**Re: PA22-033 – East Sunnyside PRD – Technical Review 1**  
4617 87<sup>th</sup> Ave NE – APN(s) 00590700016201 / 00590700016202

After preliminary review of the above referenced proposal, the Planning Division has the following comment(s):

**RDI CALCULATIONS**

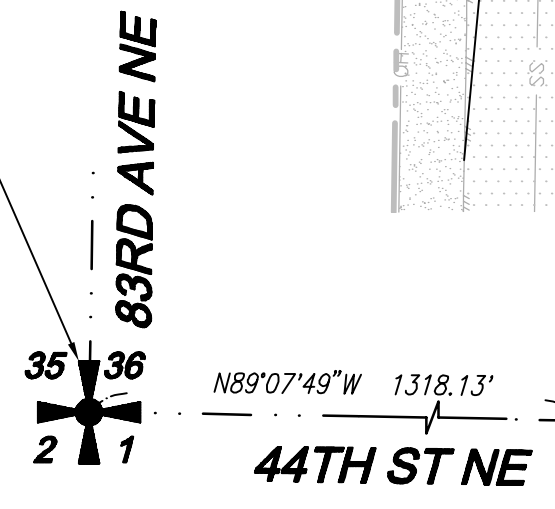
9. All figures for the required and proposed open space need to match. Currently, the figures included in the narrative, site plan, and landscaping plan all vary slightly; please revise for consistency.
10. The RDI Calculations on Sheet PP-01 and L-2 result in different incentive points; please revise for consistency.
11. To qualify for RDI bonus units under 6 (a) and (b), qualifying active/passive recreation must be clearly demonstrated.

NATURAL 9 HOLDINGS, LLC
E SUNNYSIDE PRD
PERLIMINARY GRADING PLAN

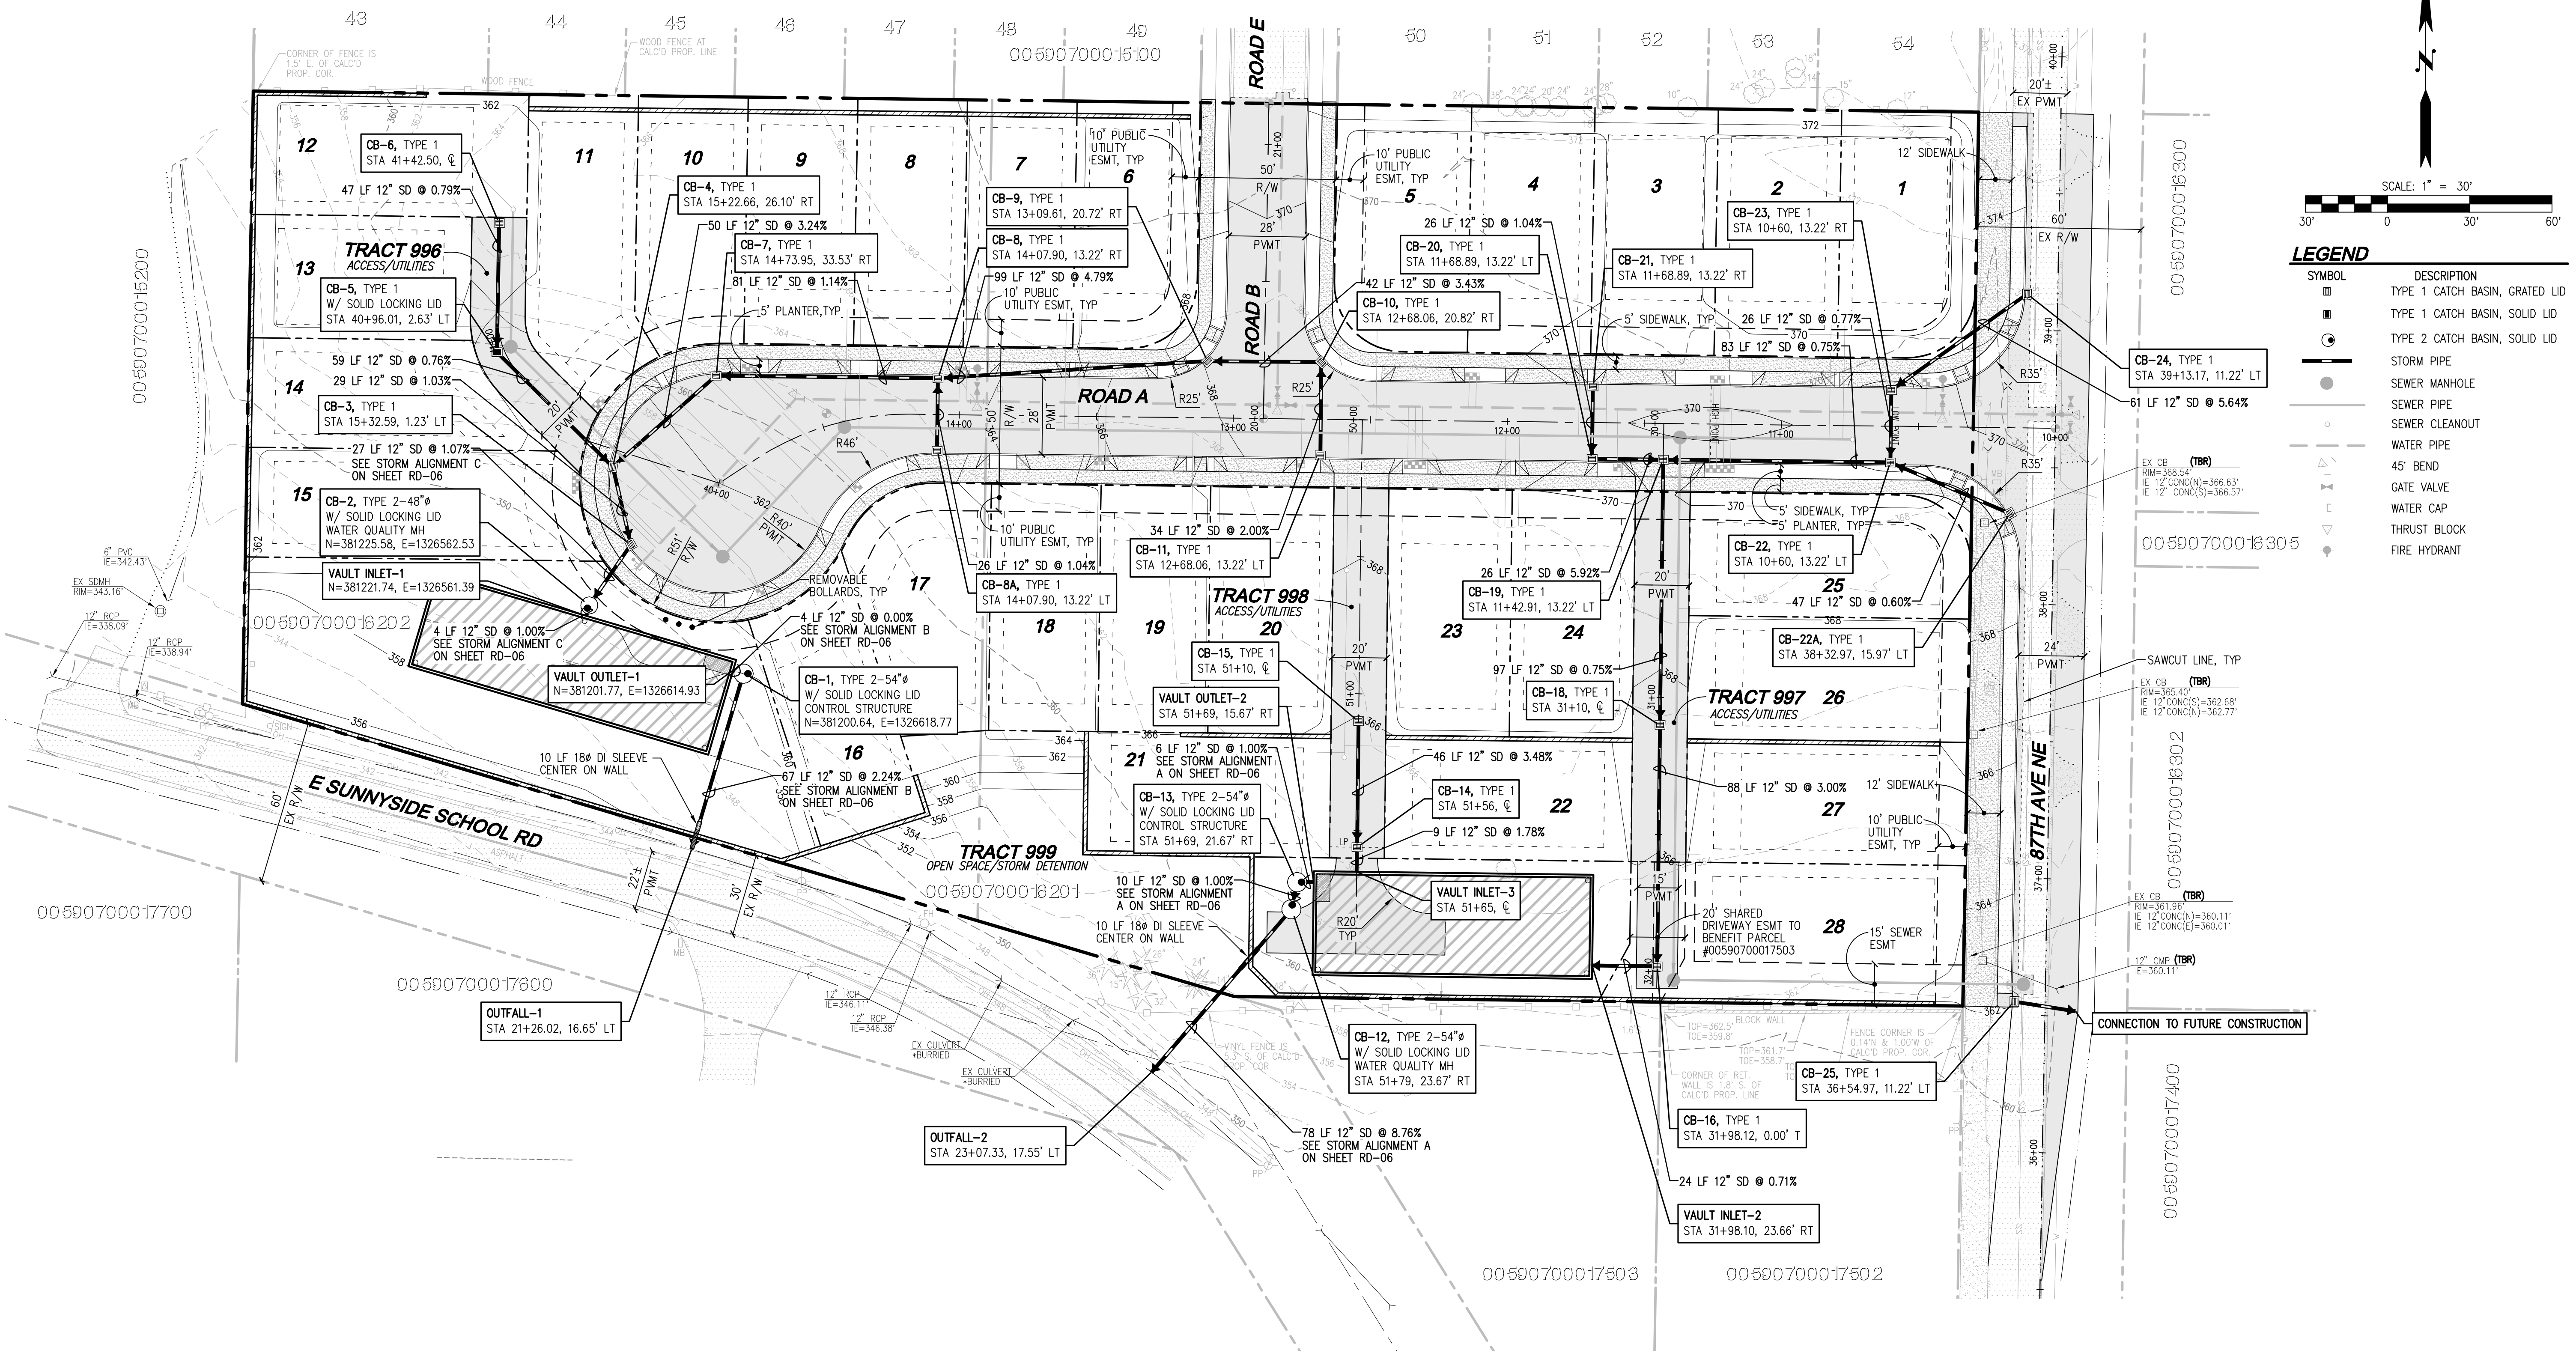
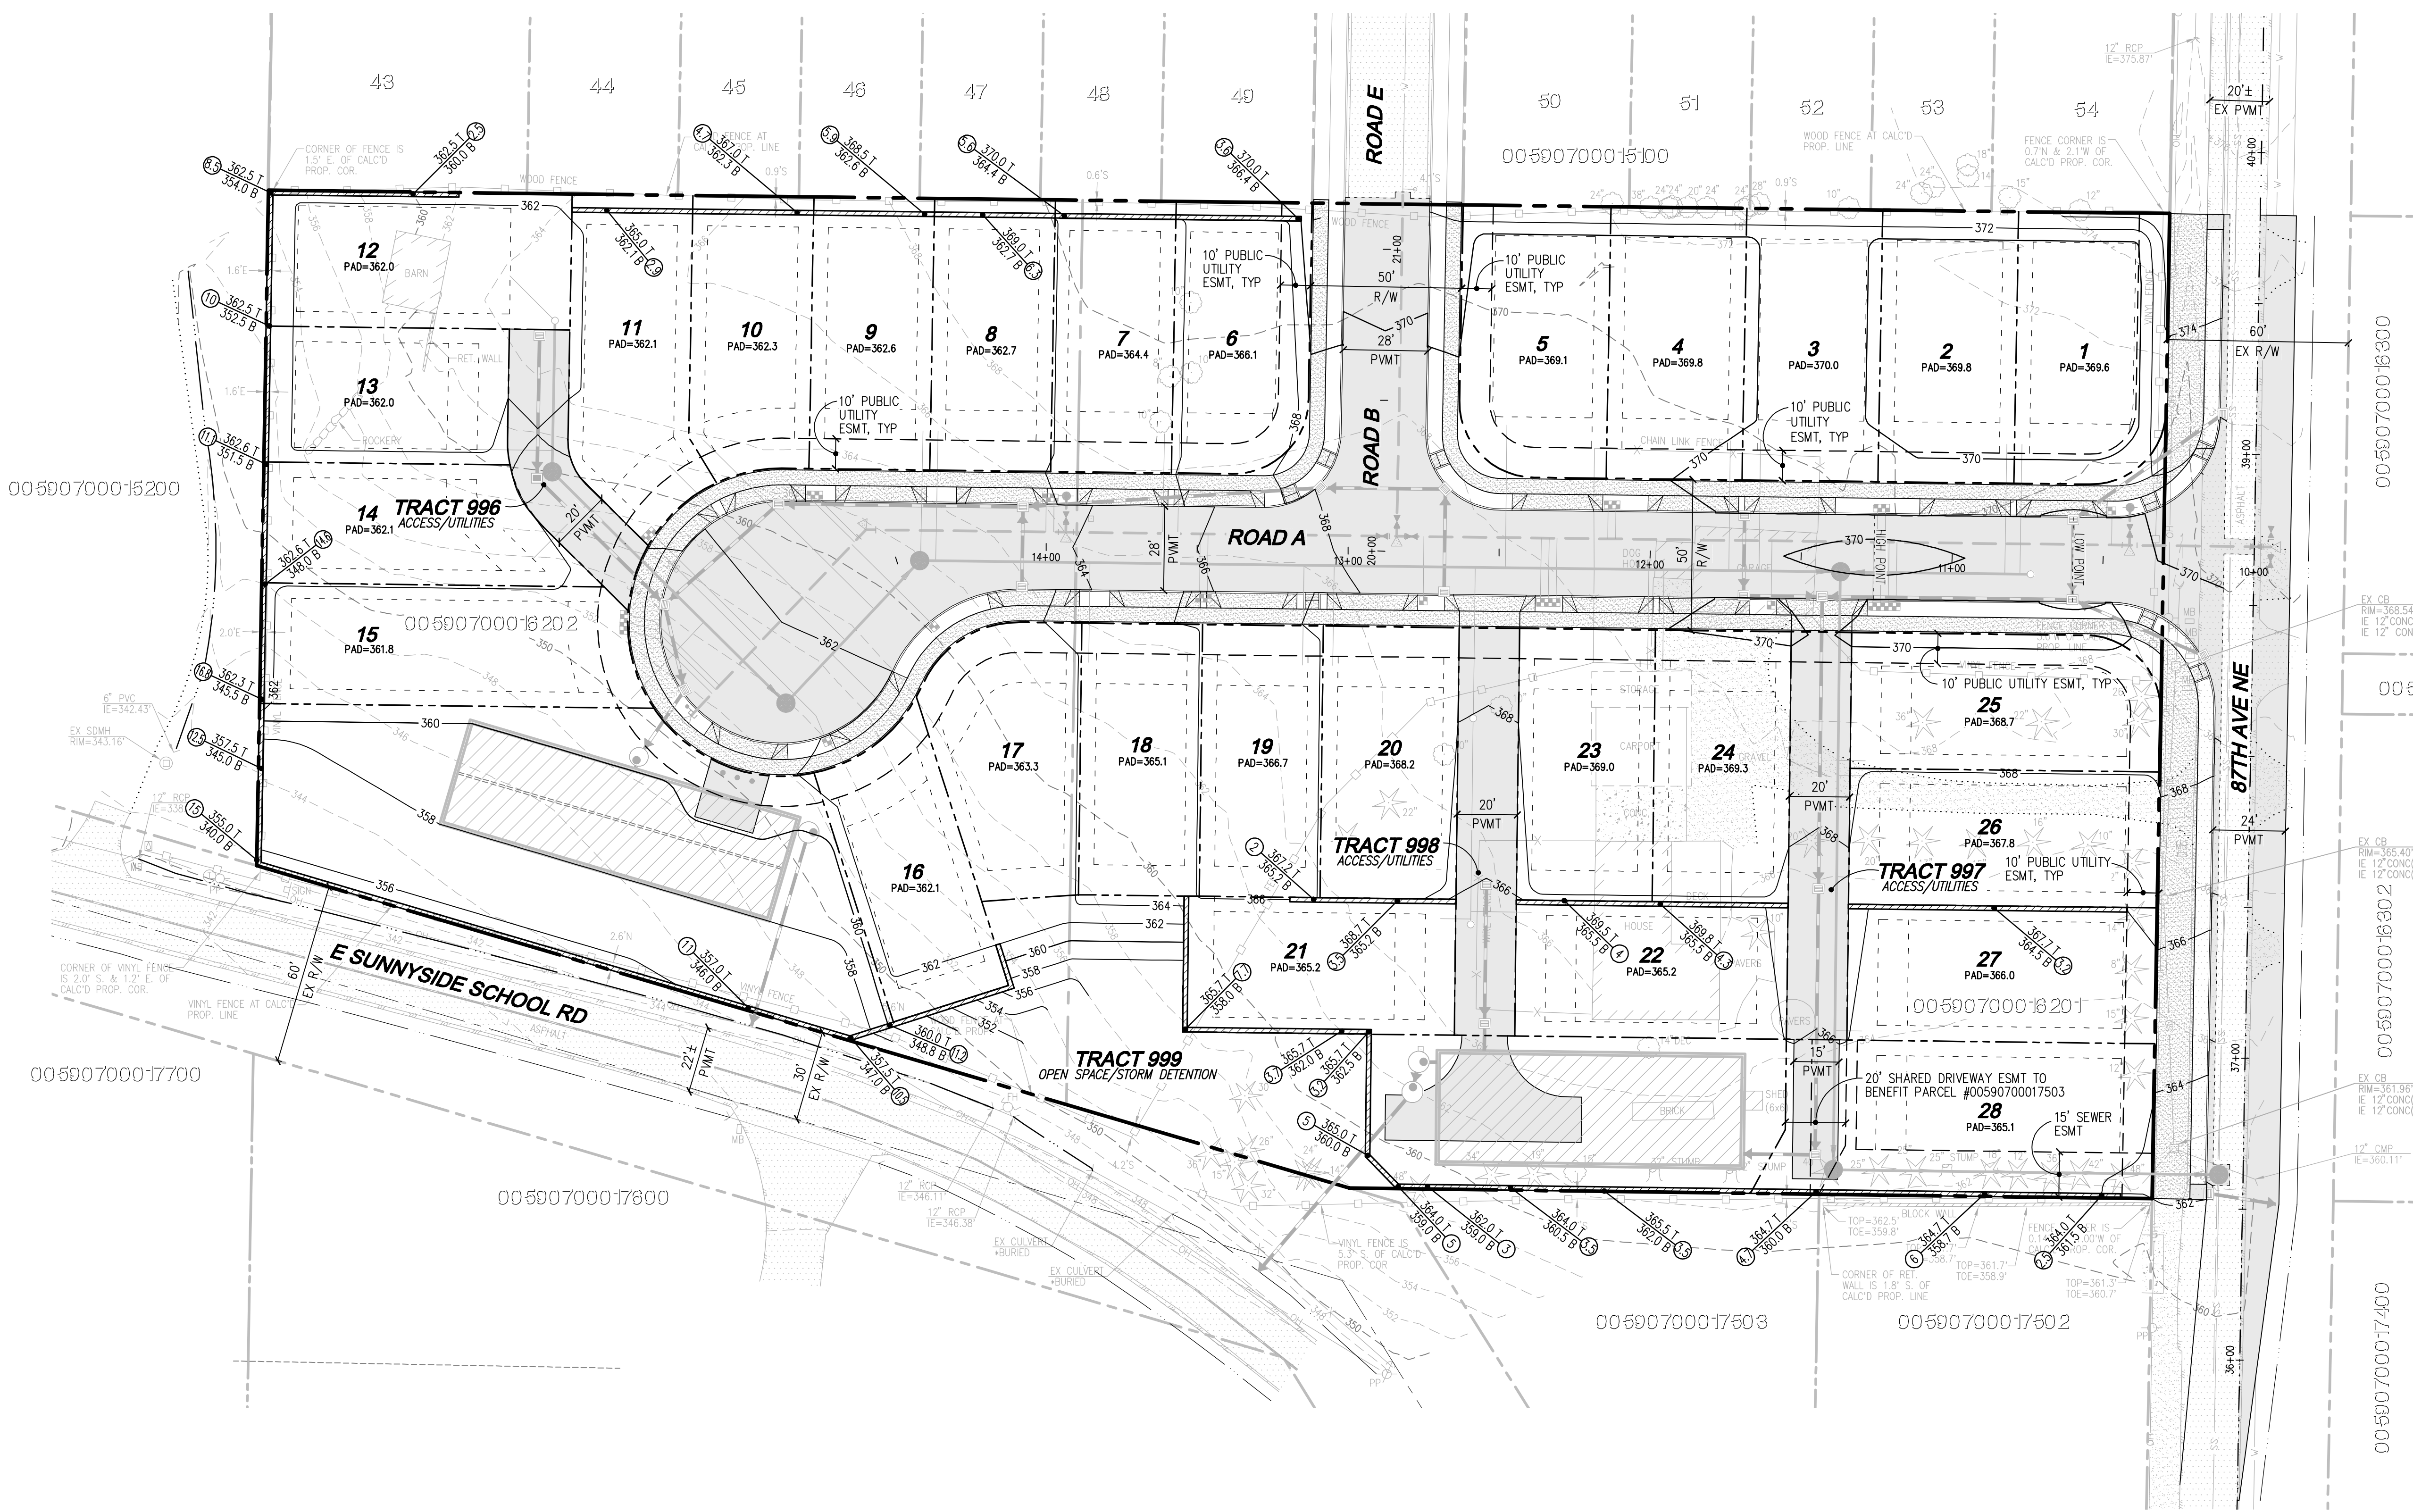
3. The design and development of subdivisions shall preserve the topography of the site by selection and location of buildings which fit the natural slope of the land. The design of the plat proposing perimeter walls ranging from 2 to 16 feet in height does not fit the natural slope of the land and the site design is disapproved, as proposed.

4. The development to the north, Prospector 2 (PA20-058), is constructing walls along the shared property line. The proposed walls for this development would result in a doubling of retaining walls. Staff is curious if this proposal is an oversight or if there is another reason why another retaining wall is proposed.

8. Based on the below image, the central area of proposed Tract 999 would be blocked off by retaining walls (see highlight). As proposed, this open space tract would not meet the requirements of *being accessible and convenient to all residents in the development* per MMCG.080.100(4). As proposed, that area would be entirely isolated and inaccessible.
